Our ref: OXF7993

**Cotefield House, Oxford Road, Bodicote, Banbury, OX15 4AQ. Application 24/00725/DISC.  
Discharge of Conditions pertaining to planning permission 21/03947/F.**

Turning to the Construction Management Plan for planning condition 3, drawing A-030-COND3 raises a number of concerns, as follows:

**LAND ADJACENT COTFIELD HOUSE**  
**OXFORD ROAD BODICOTE**  
**CONSTRUCTION TRAFFIC MANAGEMENT PLAN**  
FOR PLANNING CONDITION 3  
MARCH 2023 A-030-COND3 1:500  
For Planning application No: 21/03947/F @A2

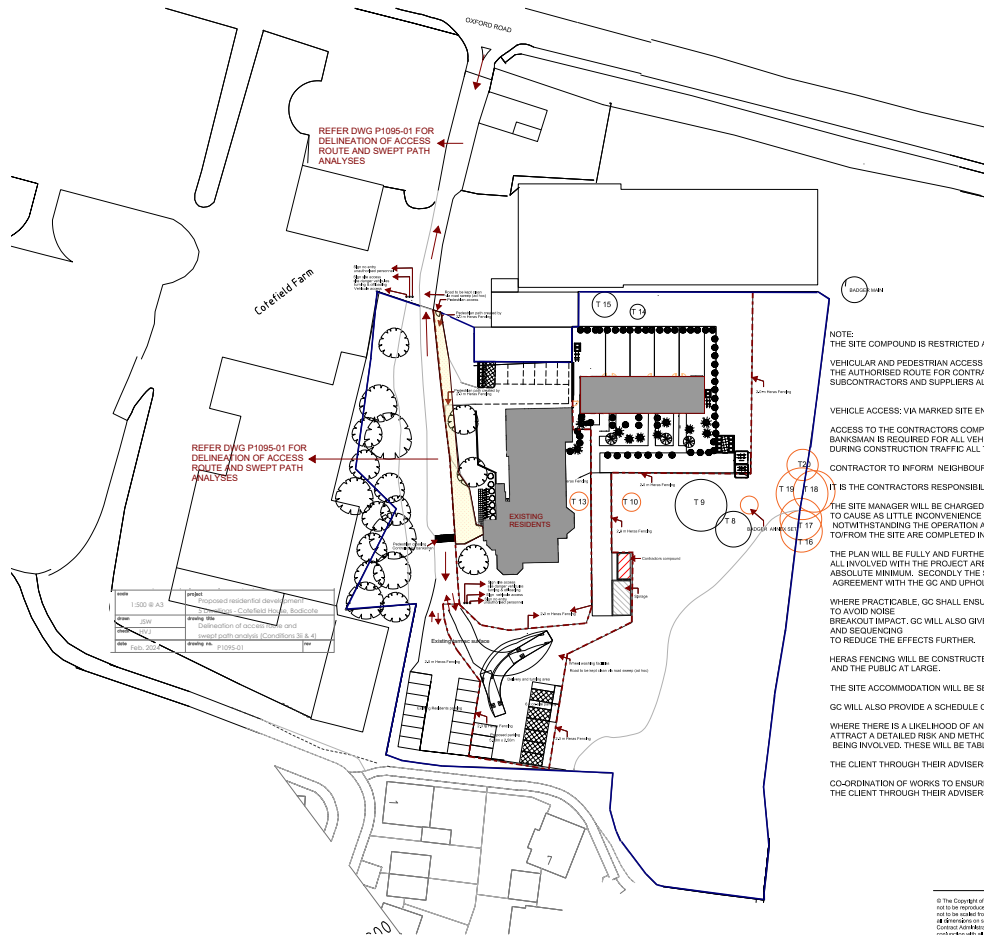
1. The contractors Compound and Storage area seem to be ridiculously small for a development of this size. It is considered highly unlikely that the necessary plant, machinery and materials will all be able to be kept within such small areas. Inevitably, this will lead to plant, machinery and materials being stored all over the site and potentially beyond its boundaries. Alternatively, the plan needs to be amended to show a more realistic area for the contractors compound and storage.

2. No toilet facilities are indicated on the plan for the use of staff working on the project. These need to be added to the plan.
3. The plan states that "co-ordination of works to ensure that no access is impeded will be the responsibility of the site manager. The client through their advisers will ensure that all their immediate neighbours are informed." Quite frankly, this statement is not believable. The applicant has a track record of not engaging with neighbours. As stated above, he has not even approached the owners of the access road to discuss arrangements. He has also not served notice on current owners. Therefore, this statement carries no weight and should be disregarded.
